September 1, 2022

Re: 8619 36th Avenue NE – Heart Saved Enhanced Services Facility (PA22-036)

Thank you for your project submittal. Upon first review of the above-referenced project, the Planning Division has the following comments/requirements. Planning Comments 1-4 shall be addressed prior to a SEPA determination or preliminary site plan approval being granted.

RE: Heart Saved Enhanced Services Facility, File# PA22-036
2 Story, 12,000sf building with retail/commercial on 1st floor and 16 bed enhanced services facility on the 2nd floor.
8619 36th Ave NE & Parcel # 004560000202

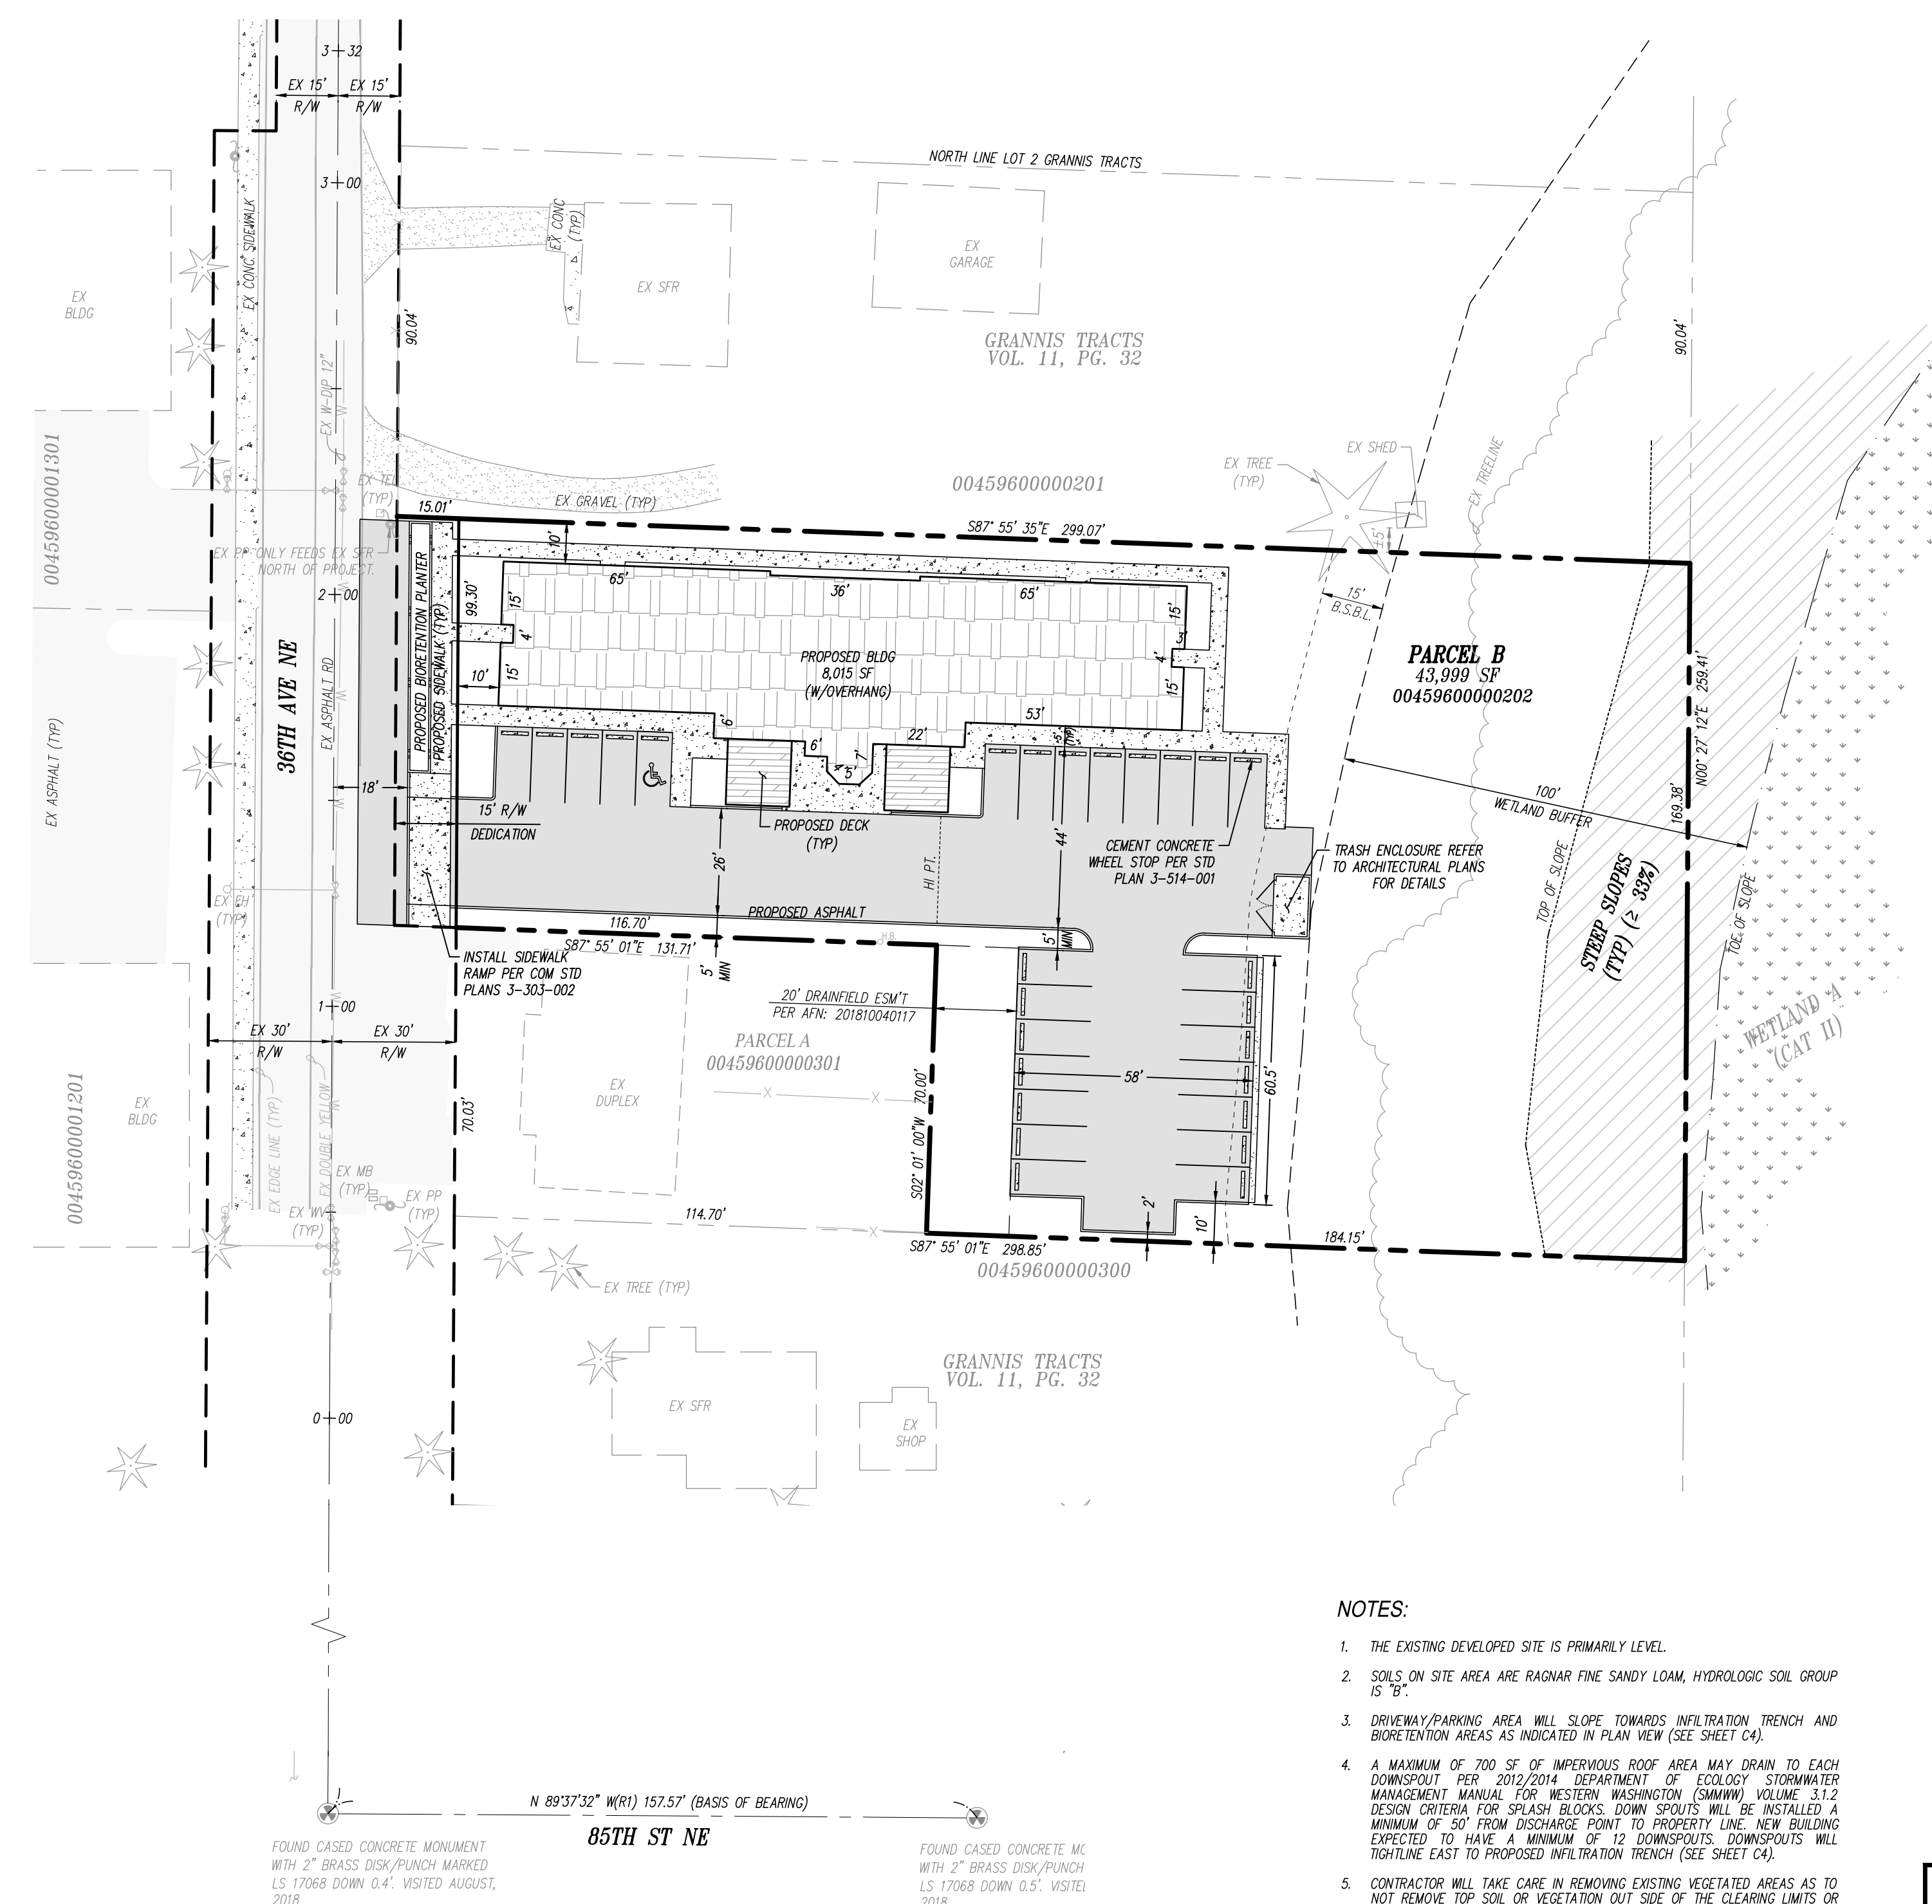
- 2) Please include the Assessor File Number (AFN) of any/all easements on the site plan.
- 3) Please provide a copy of drain field easement (201810040117) listed in Schedule B of the title report. A note regarding easement will need to be added to site plan prohibiting buildings, construction activities, etc.

- 8) Commercial buildings must be oriented towards at least one street. It does not appear that the entrance on the west elevation is open to and intended for public use. Please revise the west elevation to orient towards 36th Avenue.
- 9) The proposed building shall comply with design requirements outlined in [MMC 22C.020.250](#). The following design requirements do not appear to be met and will require revisions.

- Location of screening, where required;
 - Method of irrigation;
 - Location of outdoor waste collection and storage areas; and
 - Location of access.
- 11) A 10-foot wide L3 buffer shall be required between 36th Avenue NE and parking areas. Detail, including plant species and quantities, shall be included on the landscape plan.

Plans do not show proposed water main extension. Plans show a new fire hydrant along the south side of the drive aisle, off the center of the building. Hydrant location is good. *Water main extension with approved fire hydrants onsite will be required. The building sprinkler system FDC is required to be located within 3' to 10' from a fire hydrant.*

14. Access planned appears adequate for fire apparatus. The drive aisle access width that is shown is 26' access appears adequate. A minimum 26 feet wide fire apparatus access is required in the immediate vicinity of any building more than 30 feet in height for ladder truck operations, and within 20 feet on both sides of fire hydrants.

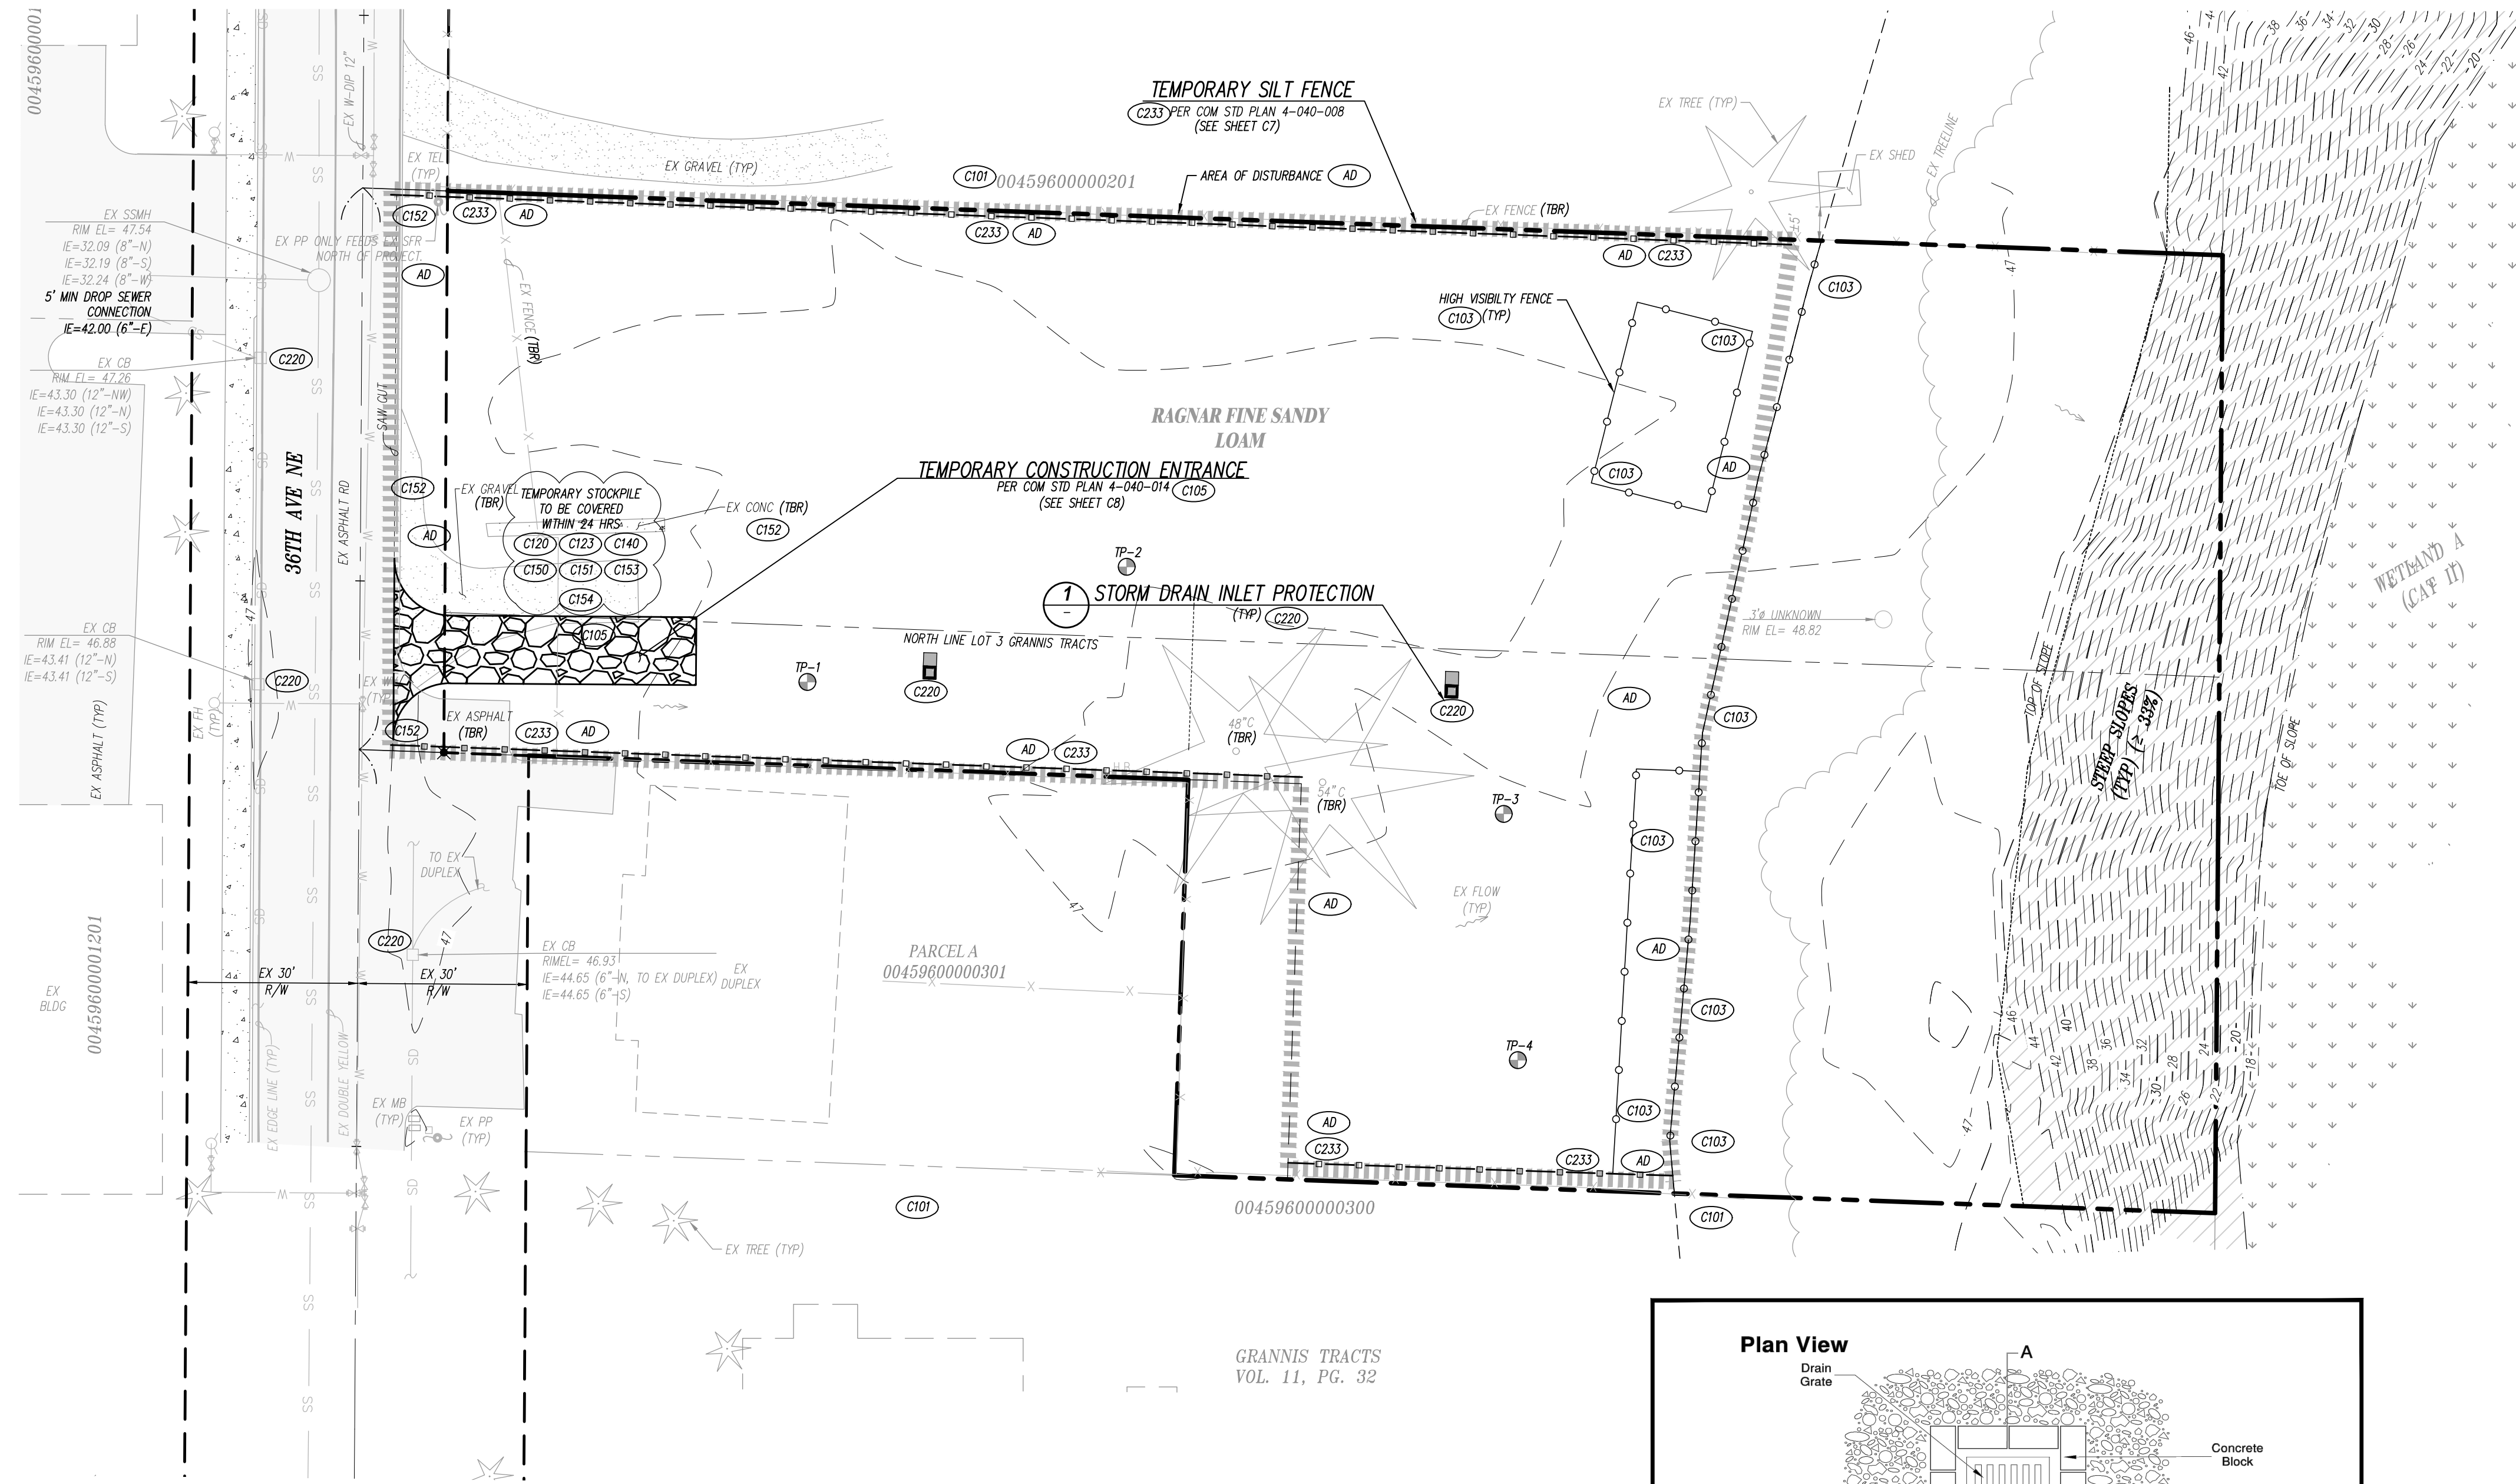
- 1) The fence adjacent to the critical area/buffer shall be two-rail fencing constructed with pressure treated posts and rails and cemented into the ground with either cedar or treated rails. Alternative materials may be used subject to approval by the city. Signs designating the presence of an environmentally sensitive area shall be posted along the buffer boundary. The signs shall be posted at a minimum rate of one every 100 lineal feet.

- 4) A mitigation planting plan will be required to be submitted identifying and proposing restoration of any degraded critical areas and associated buffers with plantings as required by MMC Sections 22E.010.220(2) and 22E.010.100(3). The mitigation plantings will be required to be installed and inspected prior to final occupancy. Mitigation will also be required for any wetland impacts.
